19584 FOUR WINDS WAY
GRADING & EROSION CONTROL PLAN
EL PASO COUNTY, COLORADO

EPC STORMWATER REVIEW COMMENTS IN ORANGE BOXES WITH BLACK TEXT

19584 FOUR WINDS WAY
MONUMENT, CO 80132
GRADING & EROSION CONTROL PLAN

GRADING & EROSION CONTROL PLAN

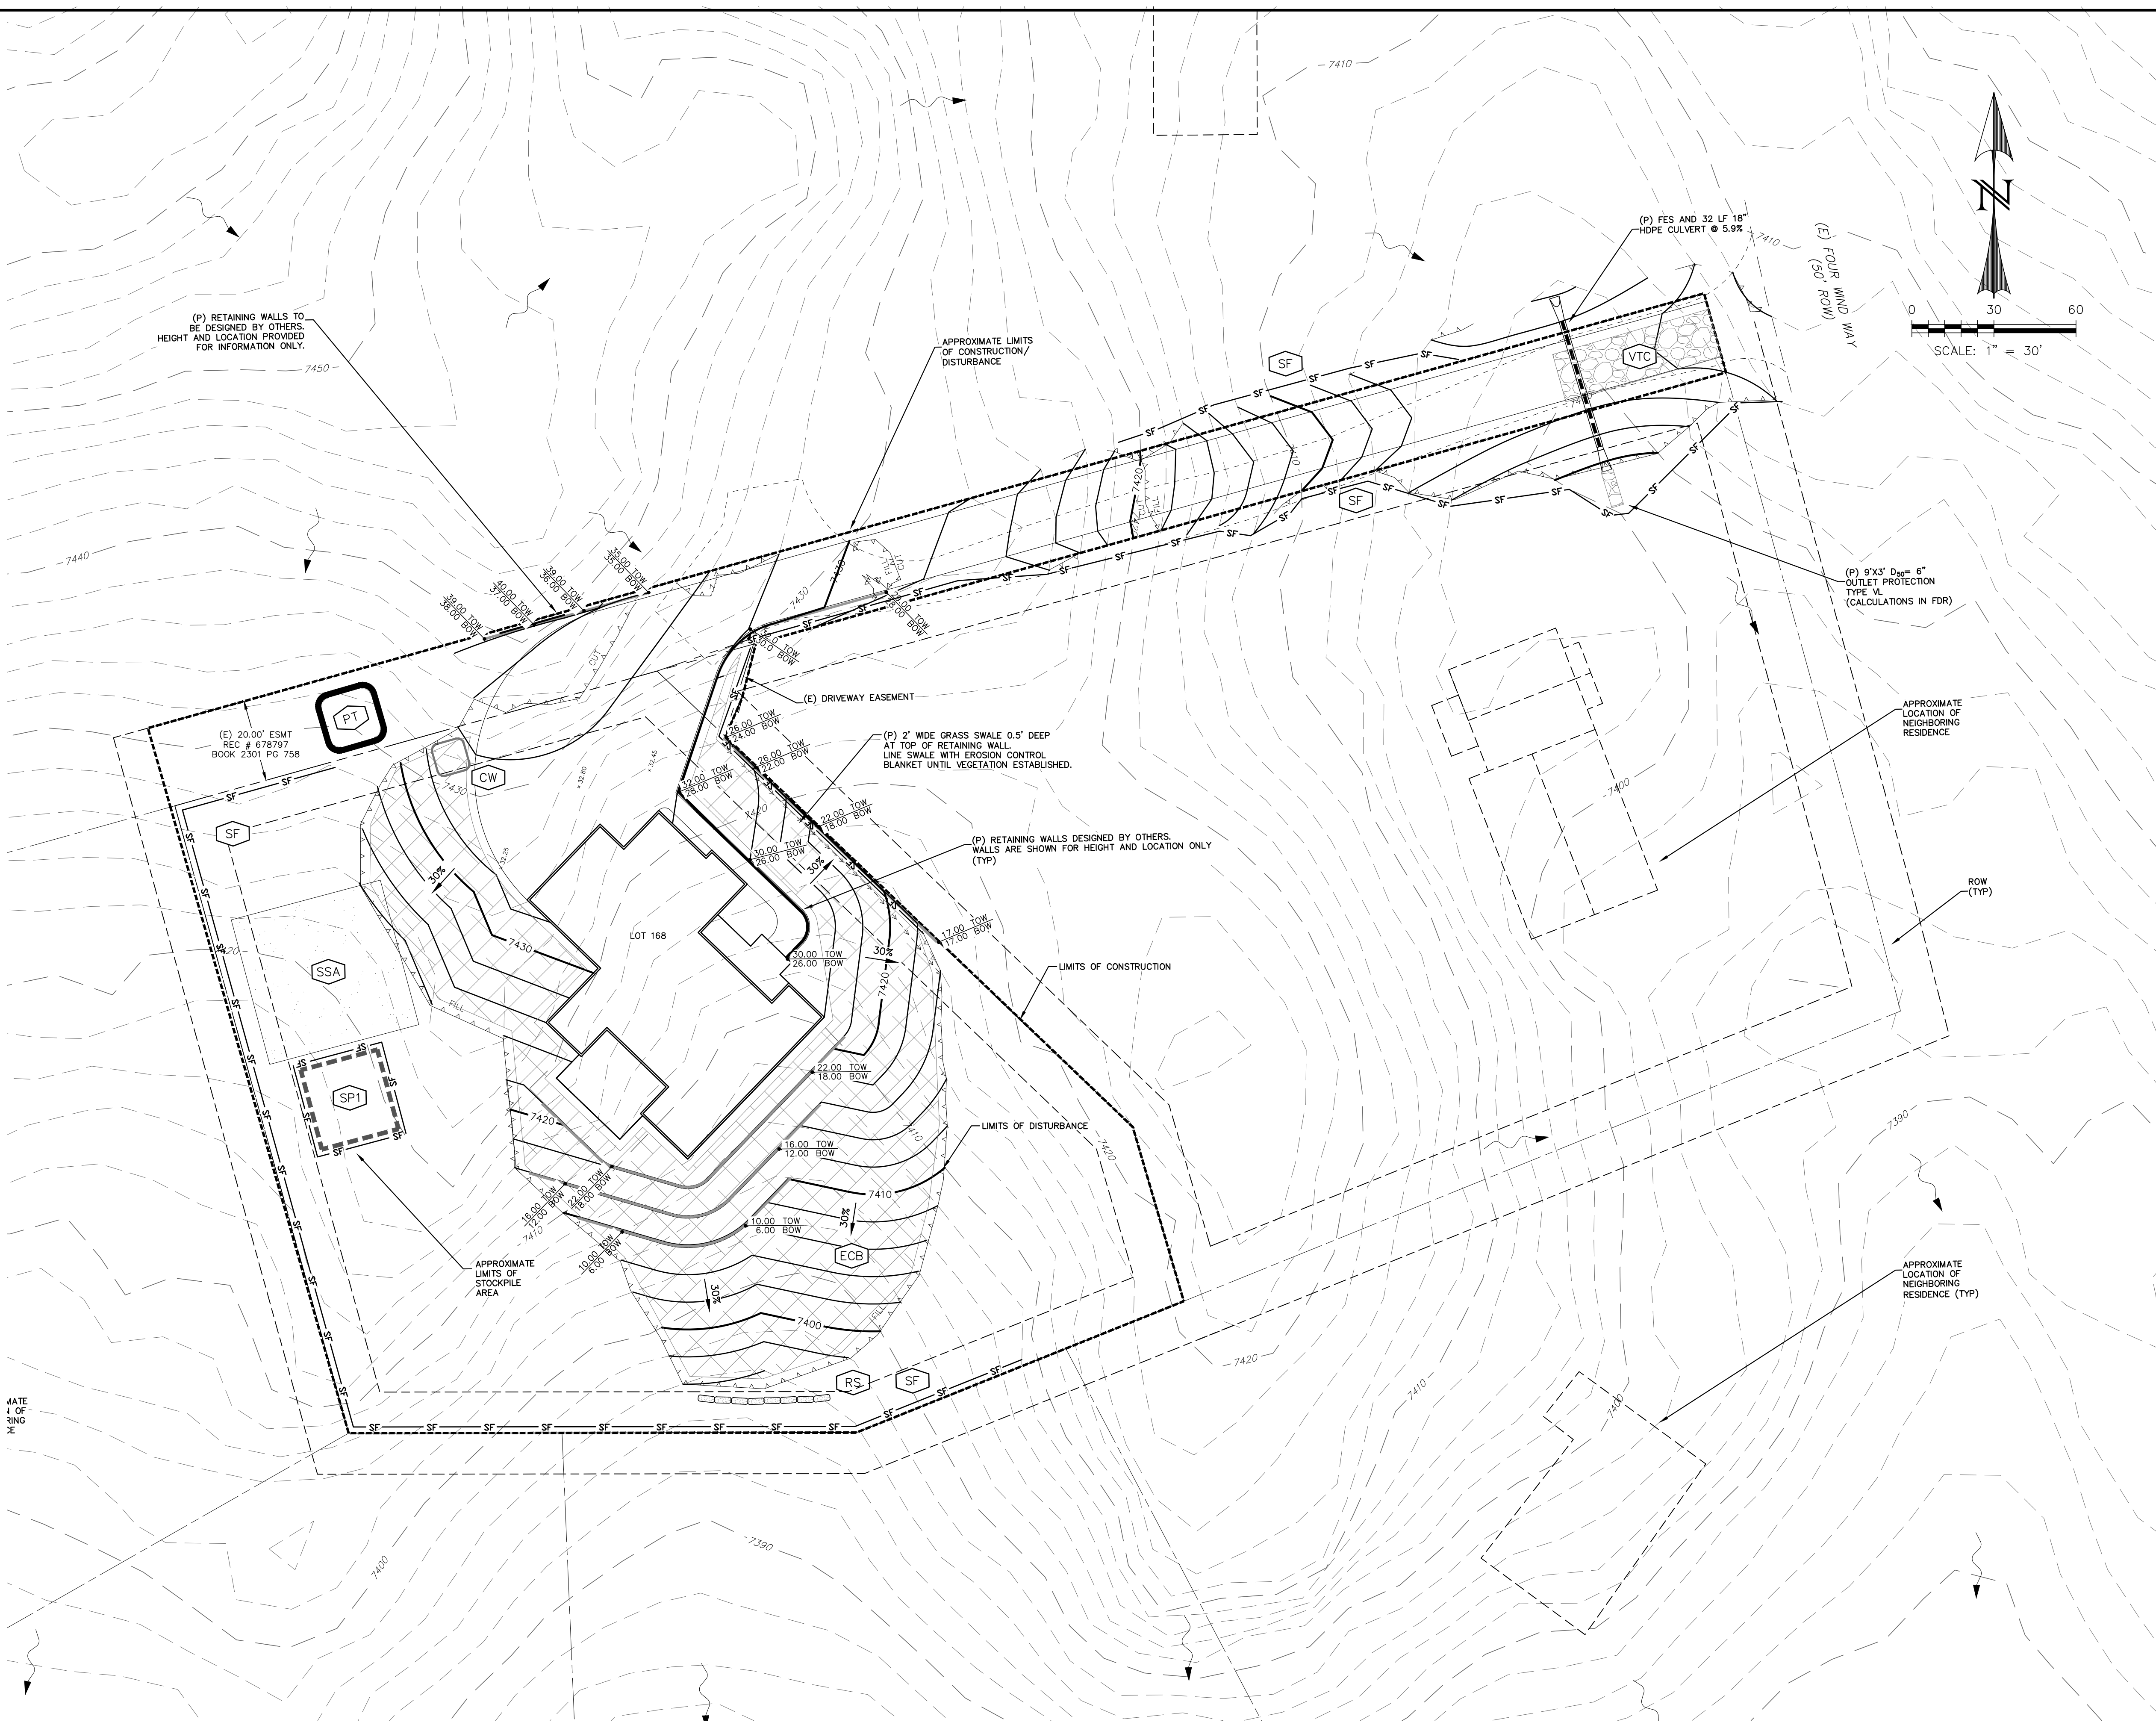
NOTE:
THE LOCATION OF SOIL STOCKPILE(S) AND STAGING AREA SHALL BE DETERMINED BY THE CONTRACTOR...
Unresolved comment from Review #1: Item "p" - delineate and/or rotate areas of cut/fill.
Review #2 update: the linetype is shown in the Legend but not on the plans. No relevant note or callout is seen on plans either.

Annotations and notes on the site plan:
- 'show some offsite drainage flow arrows as well, so it is clear which sides of the property have run-on from adjacent properties and which don't.'

- 'Approximate Limits of Construction / Disturbance'
- 'Unresolved: Show proposed topo for driveway and how it ties-in to the surrounding existing topo, since fill was brought in to build up the driveway.'

- 'Review #2 update: driveway limits shown do not align with topo. Update one of the other. Where do flows go that hit the northern edge of the built-up driveway? Is there going to be a ditch or a culvert?'

- 'Turf Reinforcement Mats must be used on steep fill embankment slopes as a permanent stabilization material method with seeding and topsoil overlay'
- 'Fill embankment slope ratio is excessive at ~64% or 1:1.5 which exceeds Soils report recommendations and LDC 6.3.5 at > 30% with severe changes in grade. Grading and site fill do not appear to meet Soils report requirements per page 9-10 or ECM 3.2.9. Please have GEOTECH confirm suitability and stability of site fill and slope and provide copy of fill soil test per Soils report pg 9.'

- 'LDC 6.3.5 Steep Lots or Parcels Terraced. Beyond any easement area, lot and parcel grades in excess of 4:1 shall be terraced or otherwise permanently stabilized.'

- 'Unresolved: Please show approximate footprint of the existing homes on the adjacent lots since they are directly downstream and could potentially be impacted by this development.'

- 'Unresolved: Show proposed topo.'
- 'What about the rest of the areas with the LOD? Indicate how they will be stabilized.'
- 'show ECB (as needed) and/or seeding/mulching along entire disturbed hillside and roadway slopes as well.'

- 'APPROX. LIMITS OF STOCKPILE AREA'
- 'add ECB to legend'

19584 FOUR WINDS WAY GRADING & EROSION CONTROL PLAN EL PASO COUNTY, COLORADO

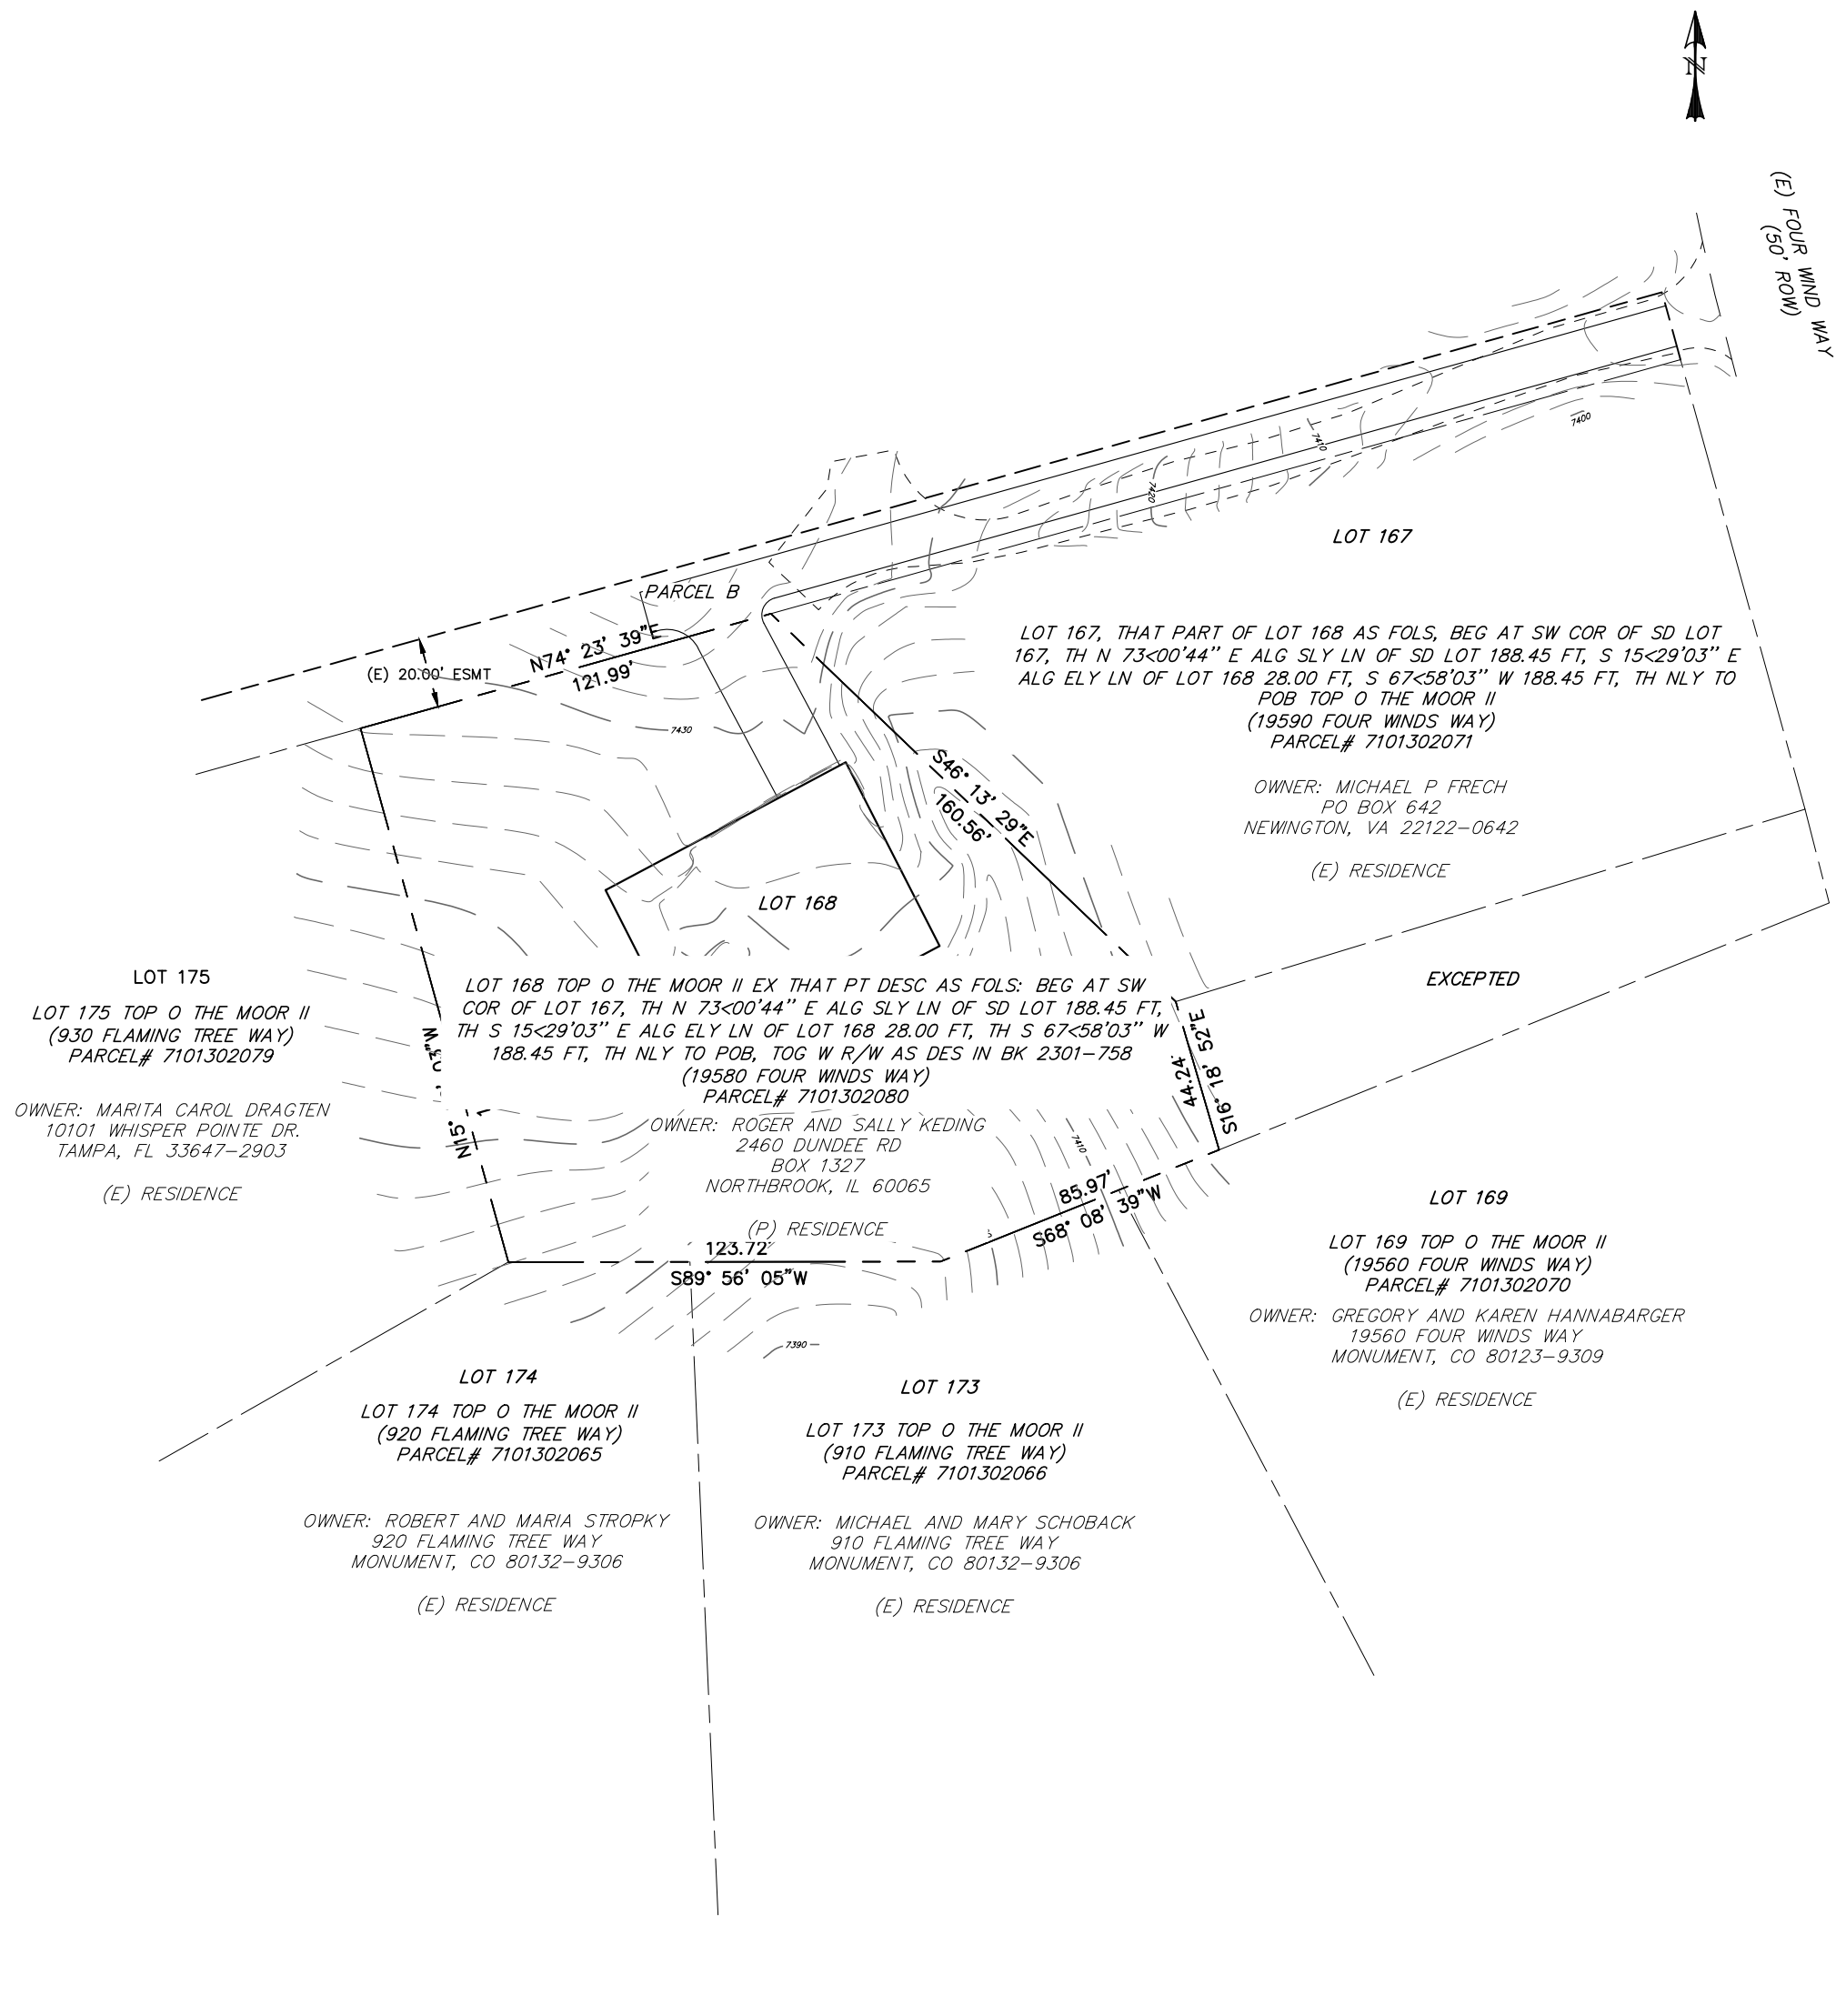
Show Standard Drainage Easement Widths and Locations along all lot lines
A site plan was not submitted as part of this review and the GEC Plan updated to reflect site plan submitted to PPRBD. There are discrepancies between the two documents
Add flag pole bearings and lengths along northern easement
Per LDC 8.4.3.B.4 Flag pole min width is 30ft. Please adjust width to min of 30ft along easement and ROW
Remove Parcel B notation
Add note "Recorded easement deed Rec # 678797 Book 2301 pg758"

This property area belongs to Lot 167. Update property lines and remove "excepted".

Update to correct PCD File # CDR-22-005
